Elizabeth Elenius, Convenor
9C/2 Bowman Street
PYRMONT NSW 2009
Tel: 9571 9727; 0409 552 117
Email: eelenius@bigpond.net.au
www.pyrmontaction.org.au

16 January, 2014

SSD 6011 – The Haymarket, South West Plot – mixed use residential

Figure 18: Macarthur Street pedestrian connection interim solution, pedestrian route (top) and visualisation of lift/stairs (bottom) (Base source: applicant's RtS and SSD 5878)

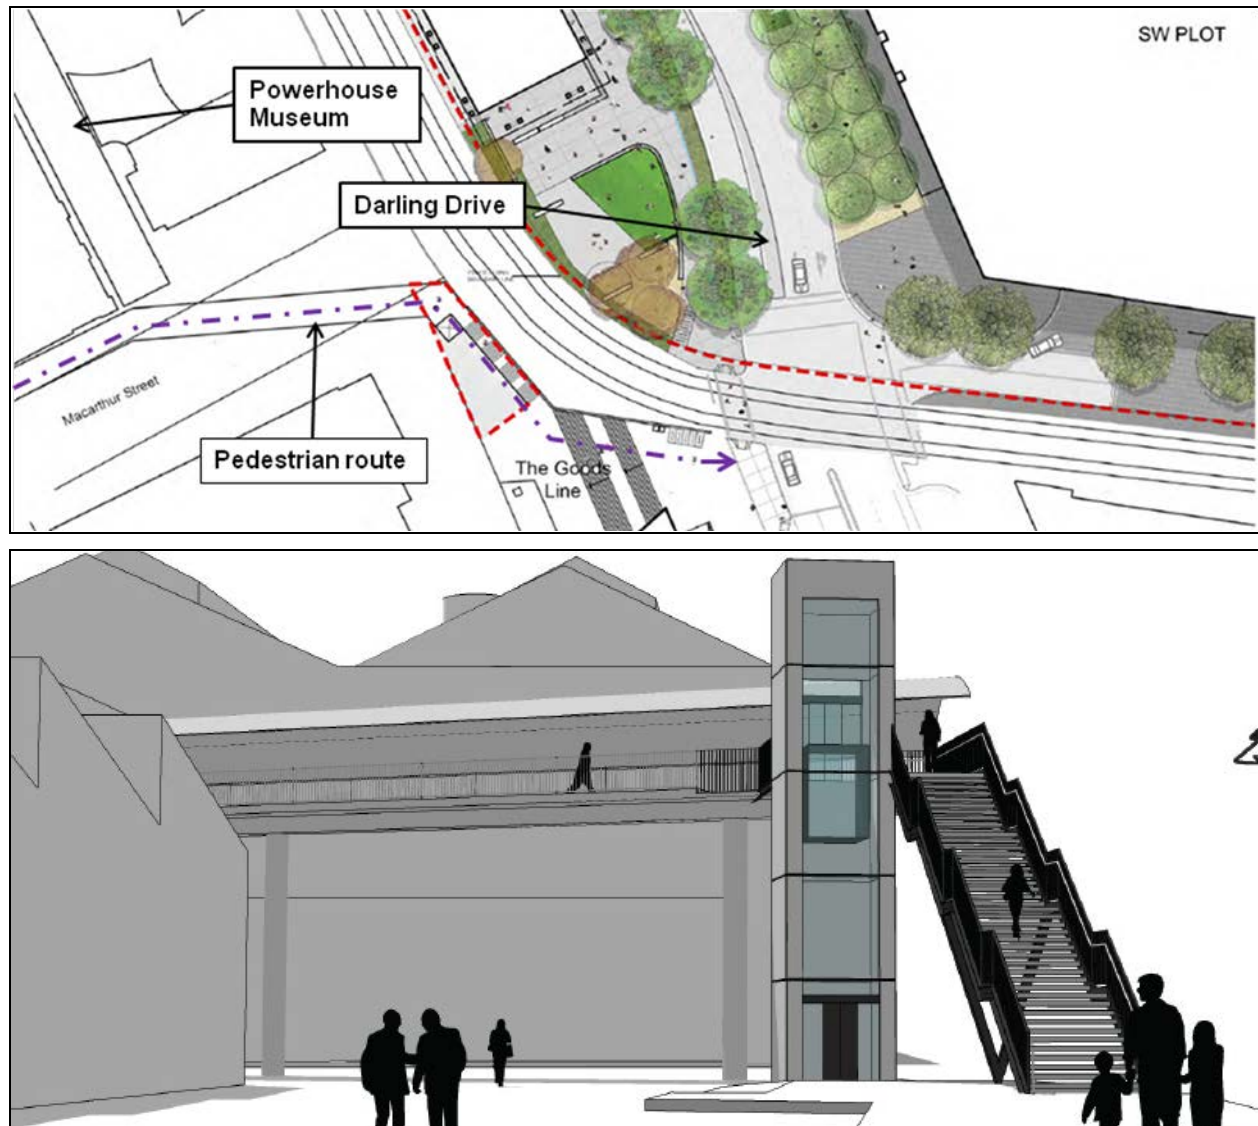
- 1.0 Access - The DA still does not address the concerns raised at consultation sessions and in submissions on the concept plan regarding the removal of the Macarthur St walkway and the unsatisfactory alternative accessway involving the need to drop down to Darling Drive and then zigzag through the site. This is an important accessway to the only bus service (501) currently available to serve the precinct, with a stop just outside the Powerhouse Museum. It should also provide a convenient, and direct link to UTS and SIT, but, as currently configured, doesn't.

Recommendation: That a direct pedestrian/cycle link be provided from Harris Street into the Haymarket Precinct in place of the circuitous link outlined in the DA. This link must also provide for the disabled and people with strollers.
